Residential development comprising 2x3-bedroom bungalow, 2x3-bedroom houses, 2x2-bedroom houses 3x4-bedroom houses along with access and parking following demolition of existing dwelling - Departure from the Development Plan.

Langford Horsemere Green Lane Climping

Thank you for your internet comments made on 3rd February 2020 which has been recorded as 'an objection' with the comments as follows:

CM/64/19/PL Langford Council objects to this application for the following reasons:

Drawing Title:
STREET SCENES/SECTIONS

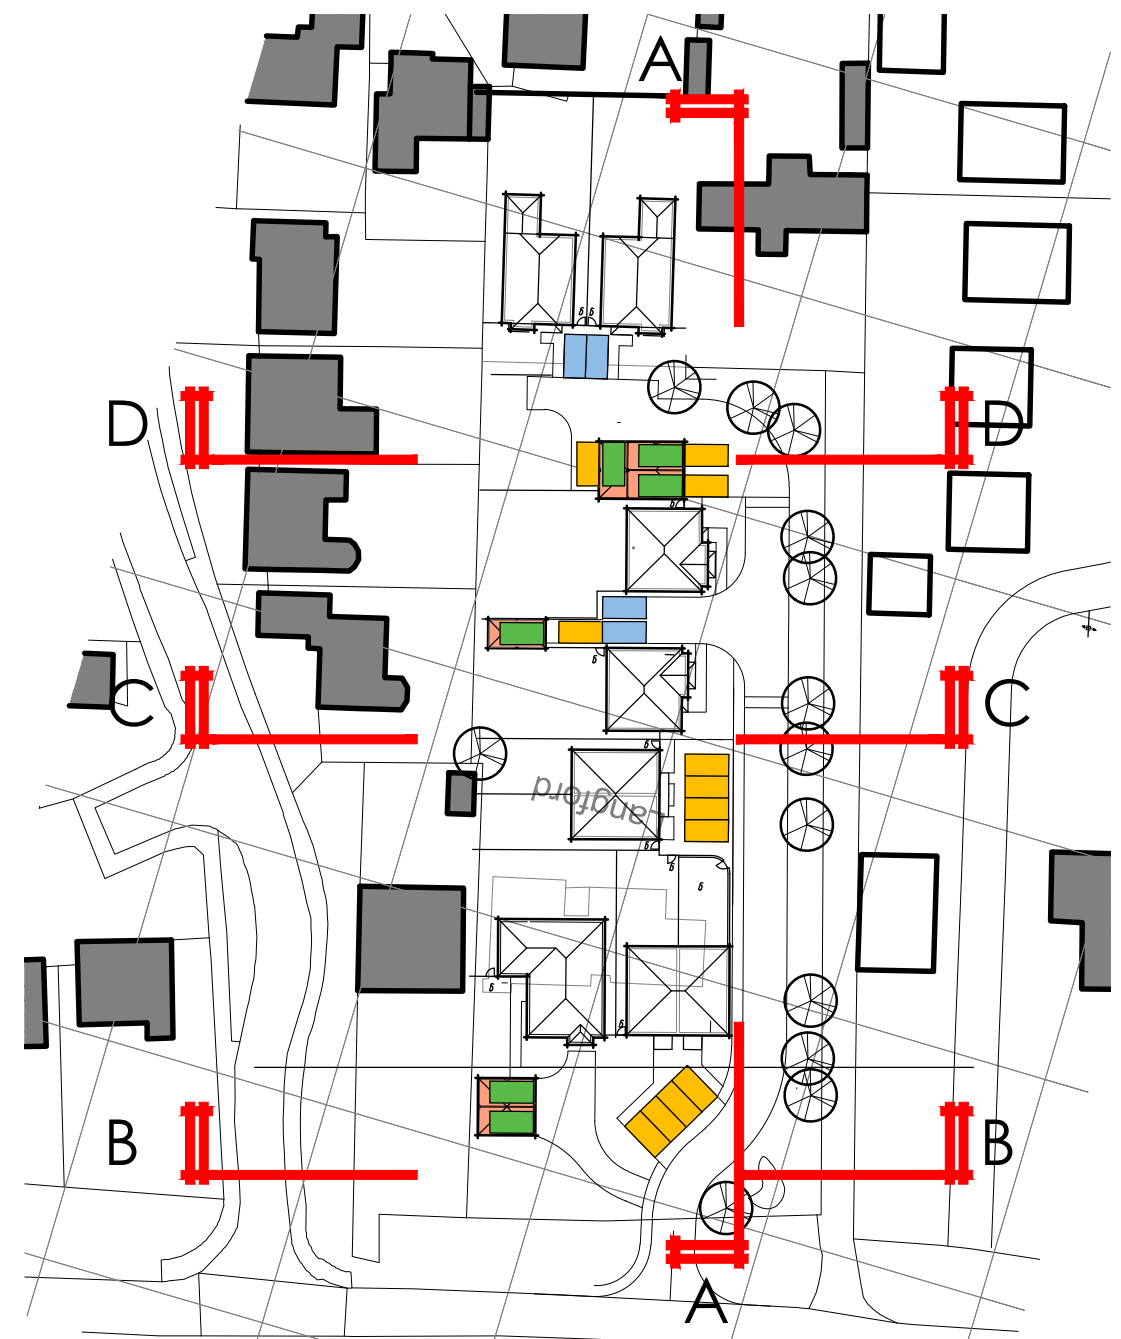
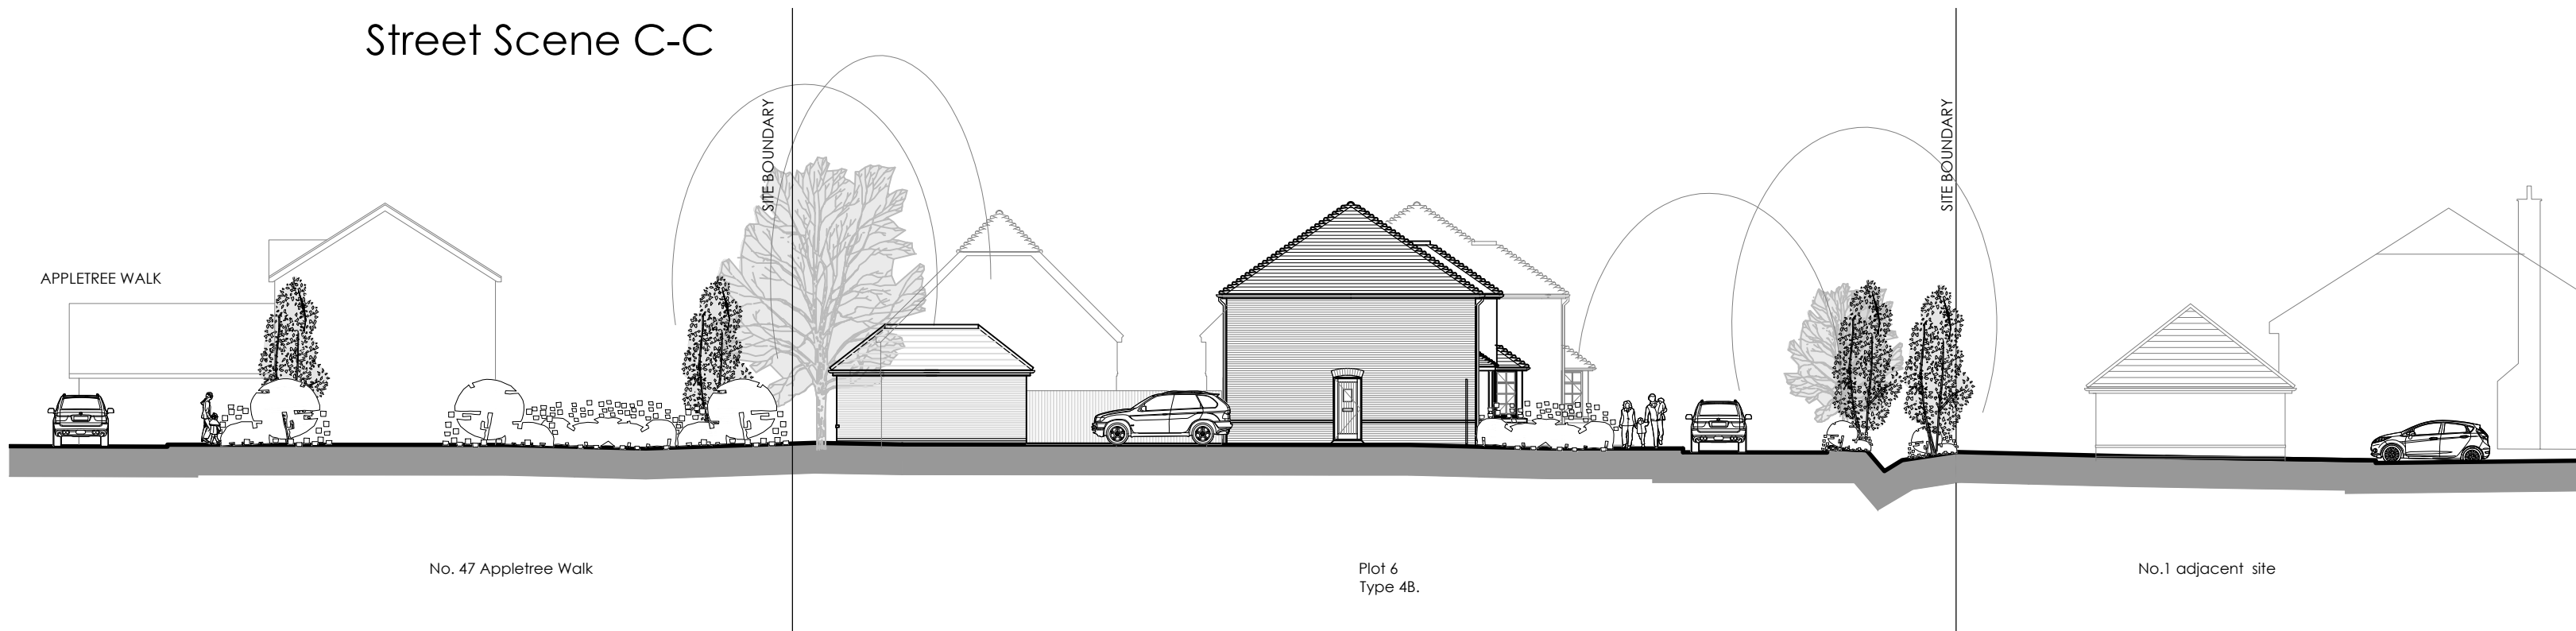
- 3. Loss of Privacy - There will be overlooking of neighbouring properties which will be detrimental to their privacy. The proposed dwellings are in too close a proximity to existing properties. This is contrary to Arun s proposed Design Guide.*

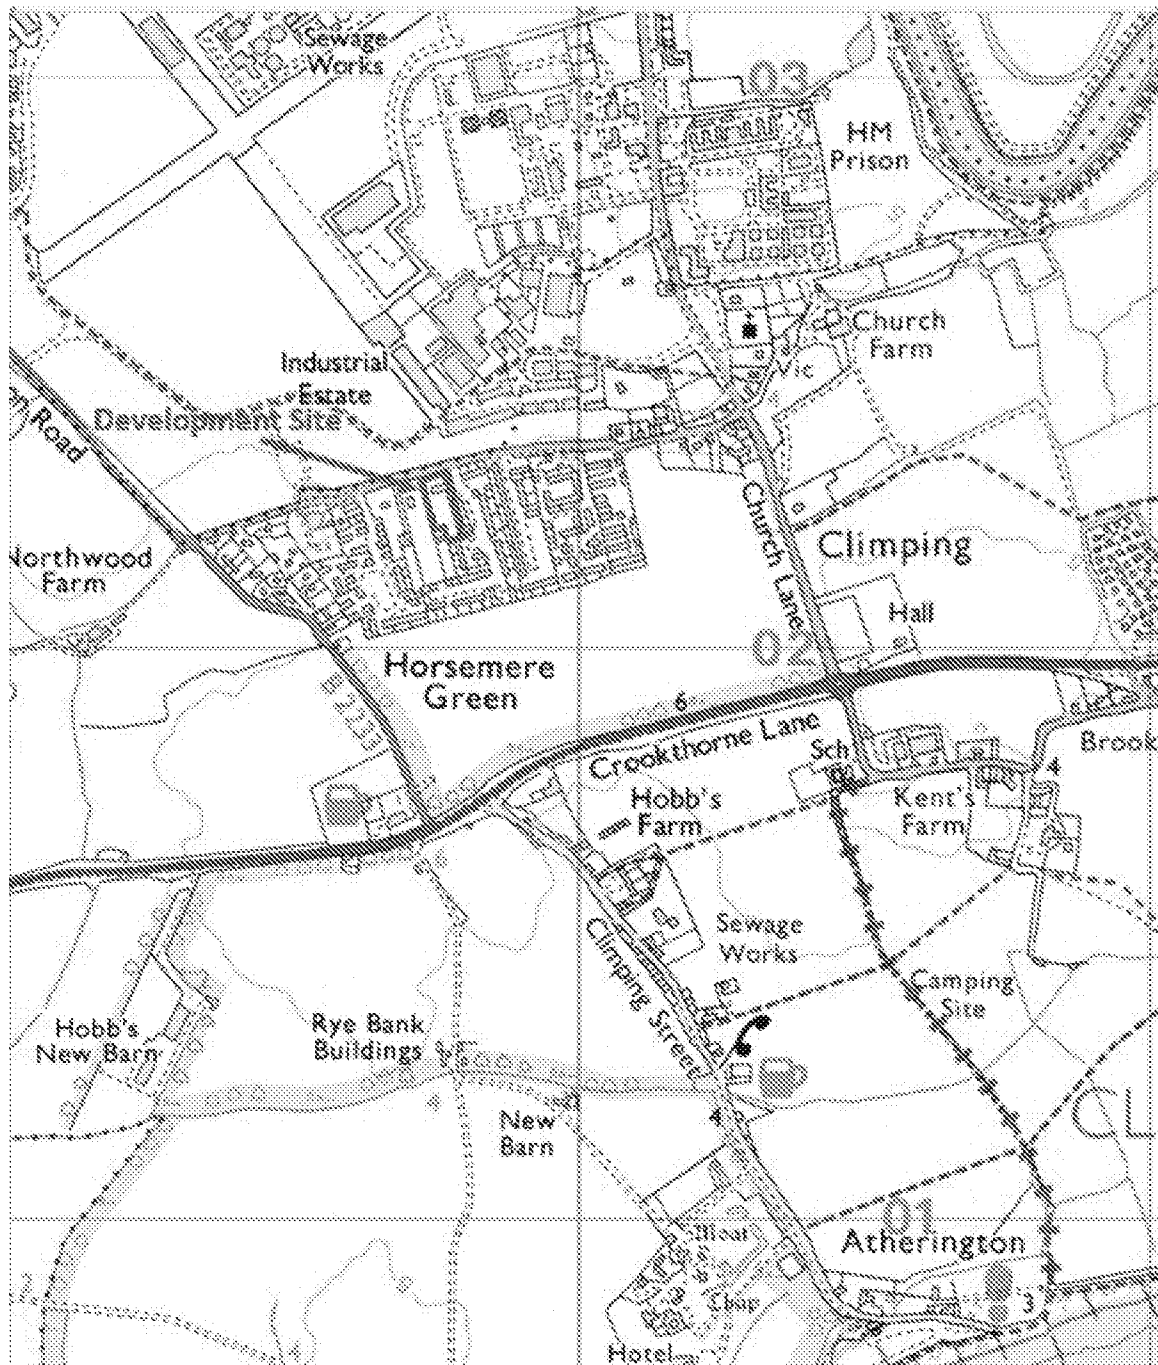
4. *Highways Impact - The creation of a further new access on to Horsemere Green Lane is not acceptable (this will be the third new access - all in close proximity to each other). With 22 parking spaces for 9 houses it seems likely that parking will spill out onto Horsemere Green Lane given those living in the dwellings, their visitors plus delivery and tradesmen vehicles. Horsemere Green Lane is frequently used as a rat run for residents of local villages as well as serving the local community, so becomes very busy at peak times. Encouraging more parked cars on it is introducing a further hazard for pedestrians, cyclist and other vehicles.*

5. *Transport Assessment - Council is concerned that the Transport assessment accompanying the application is flawed. The number of in and out trips for vehicles appears very low for 9 houses as the residents will be highly dependent on their cars as per the established local experience. Given the hazard for pedestrians and the lack of a continuous pavement there will be little use of public transport (as suggested) as reaching buses or trains requires a walk along/in Horsemere Green Lane and uncontrolled crossings of busy HGV routes. For instance, there is no safer route to school identified by County for walking or cycling to school, given the lack of pavements/cycle lanes/safe crossing points, so taking a child to school/pre-school will likely be by car. This potentially creates at least 2 movements out and 2 movements in per household (18 each way) before allowing for other vehicular movements (work/social/food shopping etc.).*

Drawing Title:
SITE LAYOUT

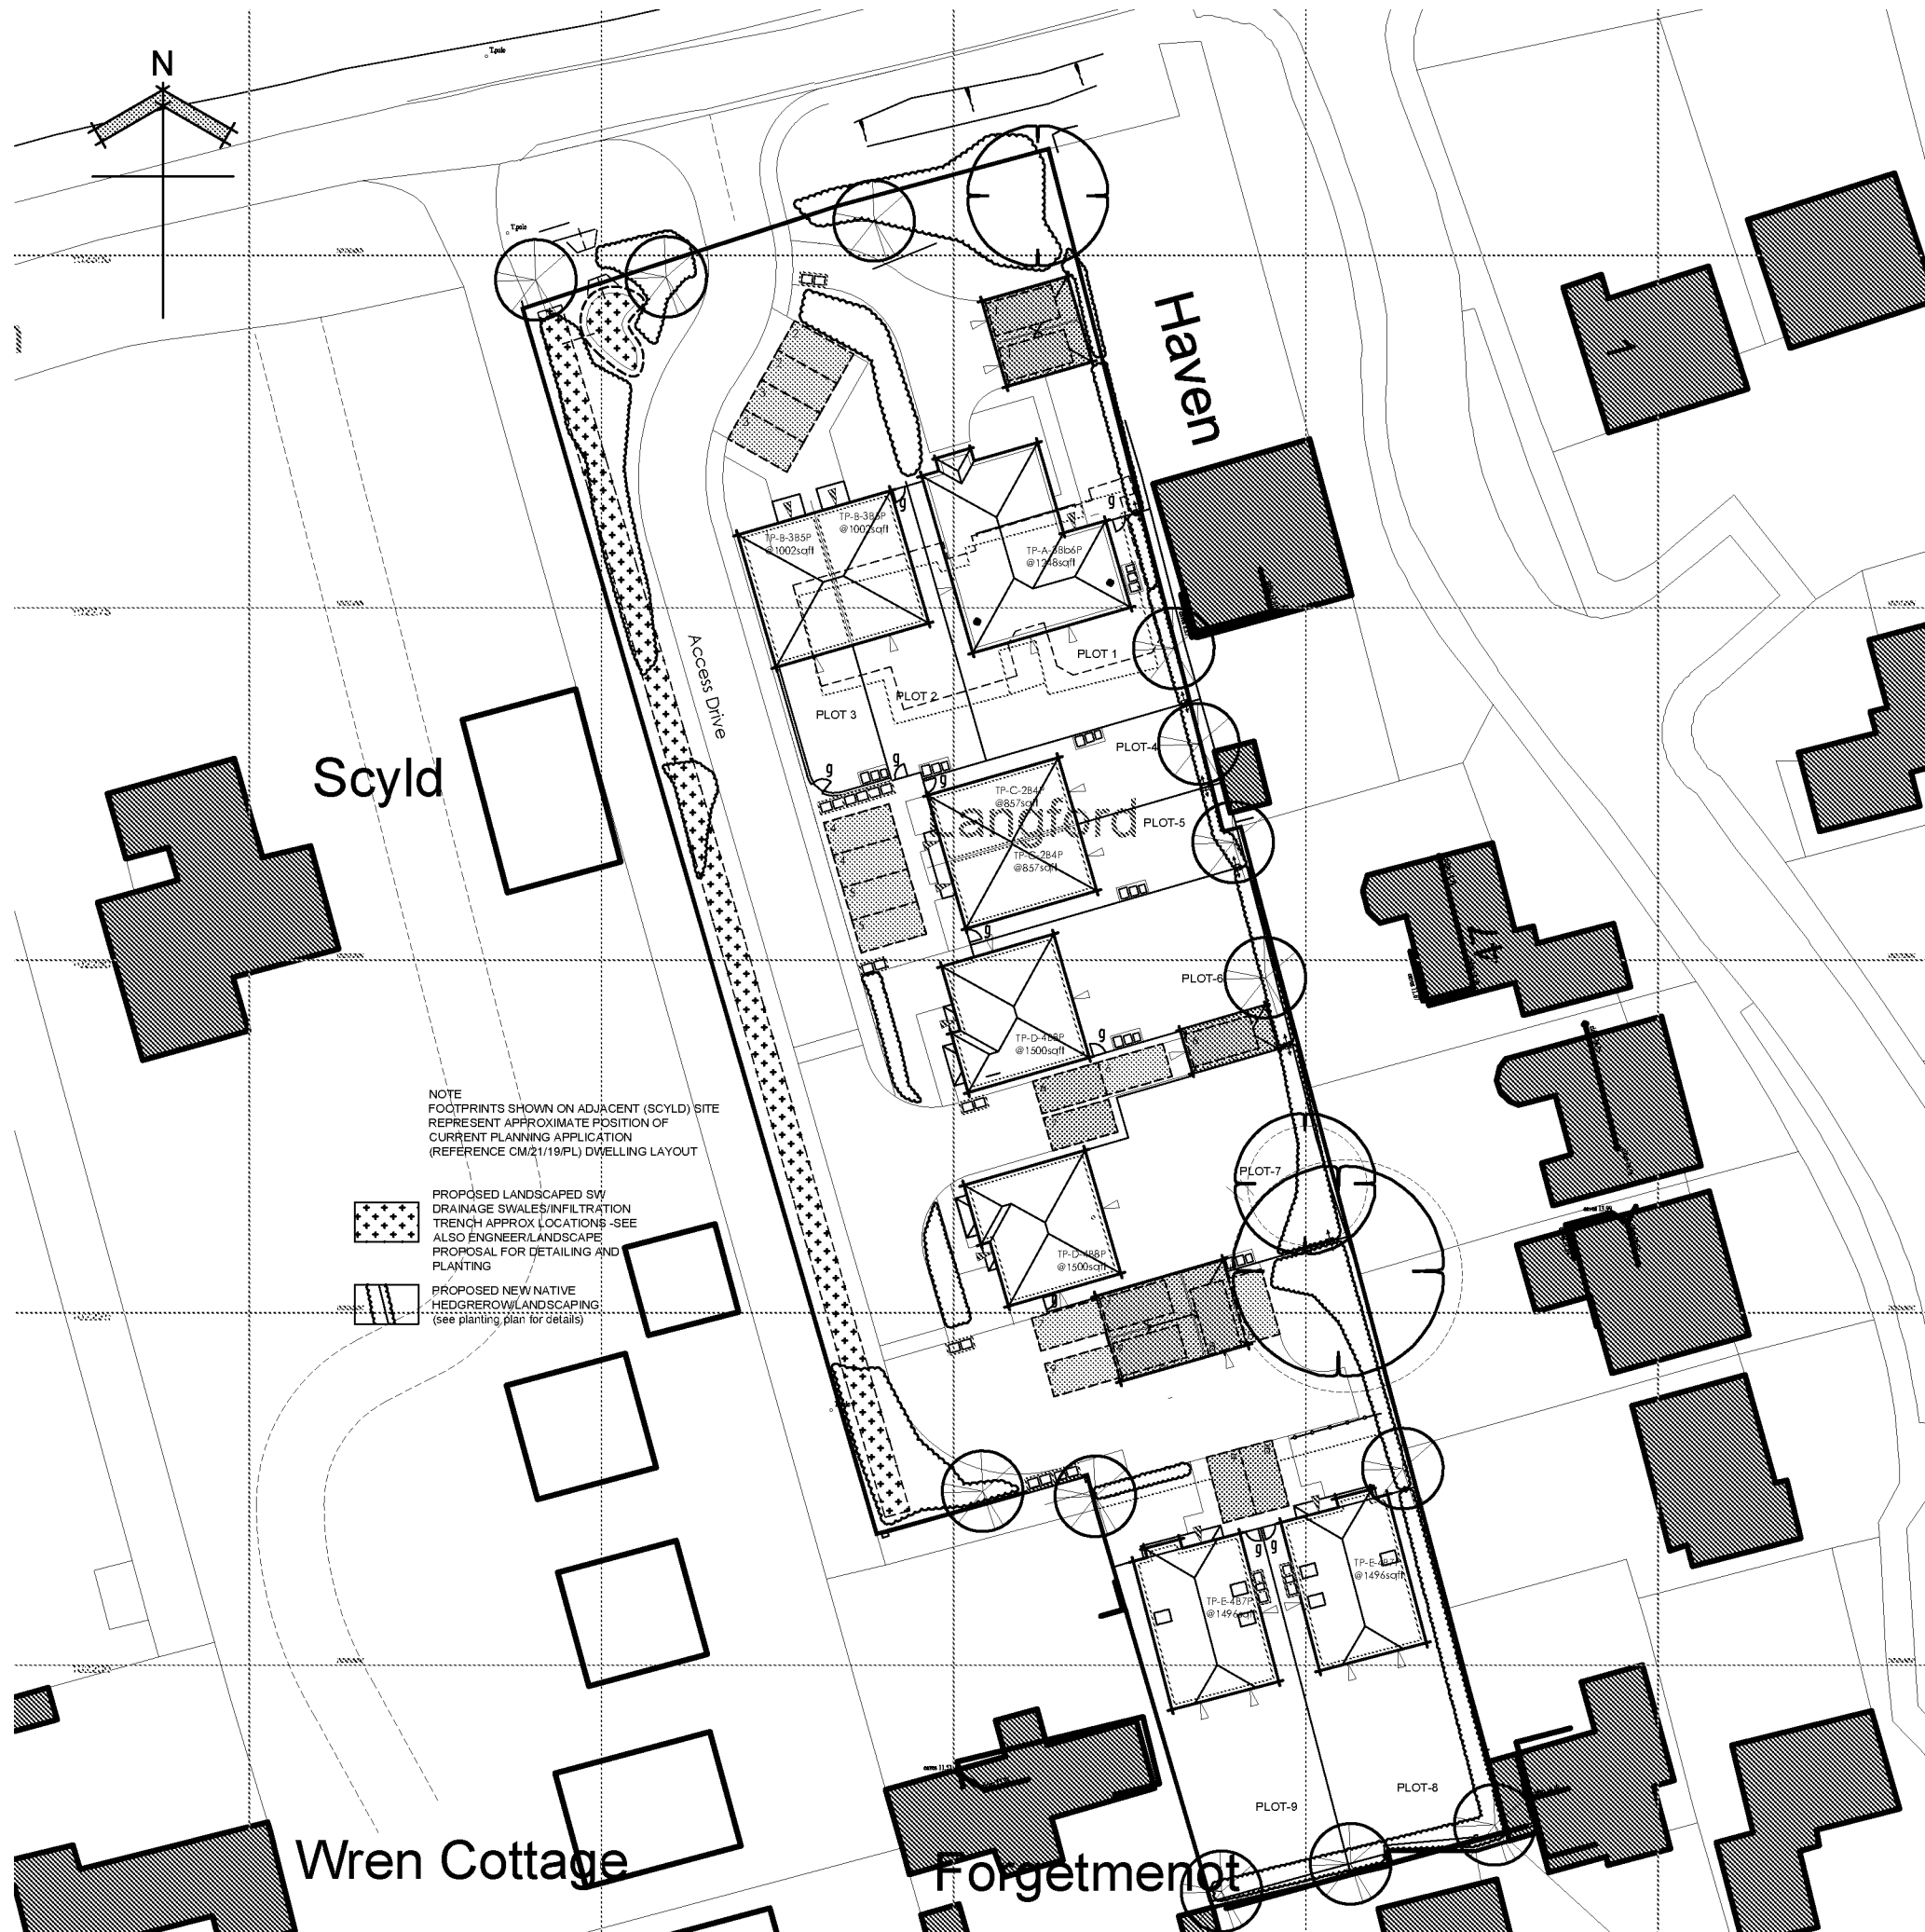
- 1. Countryside - The site is outside the built-up boundary area on land designated as Countryside and the application is therefore contrary to Arun Policy C SP1 Countryside that provides the context to the Clymping Neighbourhood Plan.*
- 2. Over Development - It is an over intensive high-density development which is against the character of the area and will be detrimental to the street scene. This is contrary to Clymping Neighbourhood Plan Policy CPN 11 Quality of Design. The housing density at 21 per Ha is 50% greater than that of approved CM/21/19/PL (Land adjacent to Scyld), and this is also higher than other nearby developments. The proposed Arun Design Guide recommends up to 15 per Ha.*
